Your Ref: OWPC16366
Our Ref: FG/162/17/PL 10-10-2017
Please ask for:
Mrs A Gardner

Demolition of existing detached garage & erection of 1 No. dwelling.
1 Upper West Drive Ferring

Thank you for your internet representation made on 17th November 2017 which has been recorded as '**an objection**' with the comments as follows:

EXISTING SITE PLAN 1:100

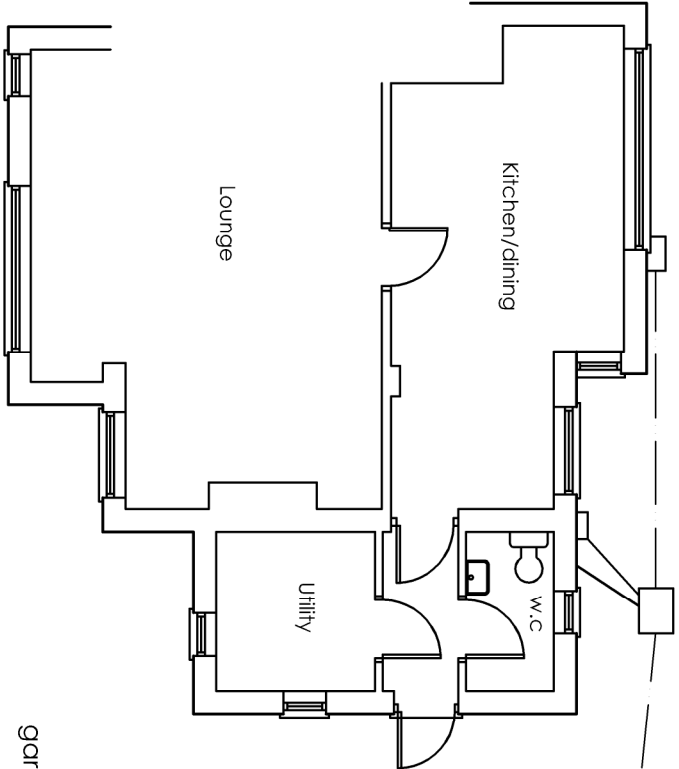
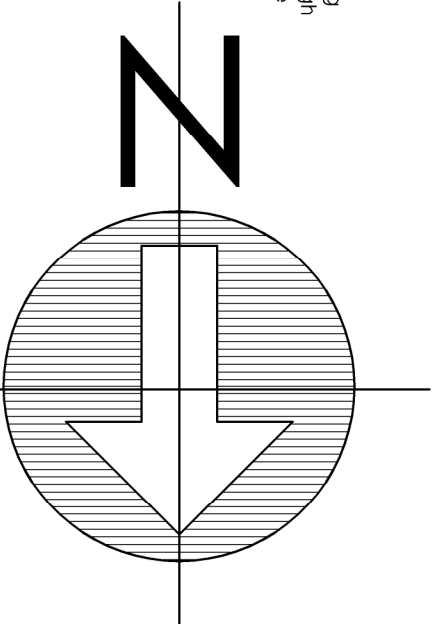
I object to this application. Firstly, it would be an overdevelopment of the site that would be cramped and visually unattractive. The gap between No 1 Upper West Drive and the bungalow would be only 2 metres, allowing just 1 metre either side of the proposed dividing fence, inadequate for both access and maintenance. In addition, the depth of the proposed back garden is insufficient and yet "permitted development" would allow an extension into this already inadequate garden area. Secondly, the development would pose a future risk to the large and attractive sycamore at the front of the site. The tree is protected with a TPO but is very close to the proposed bungalow and it's easy to envisage future complaints about the tree endangering the bungalow, etc.
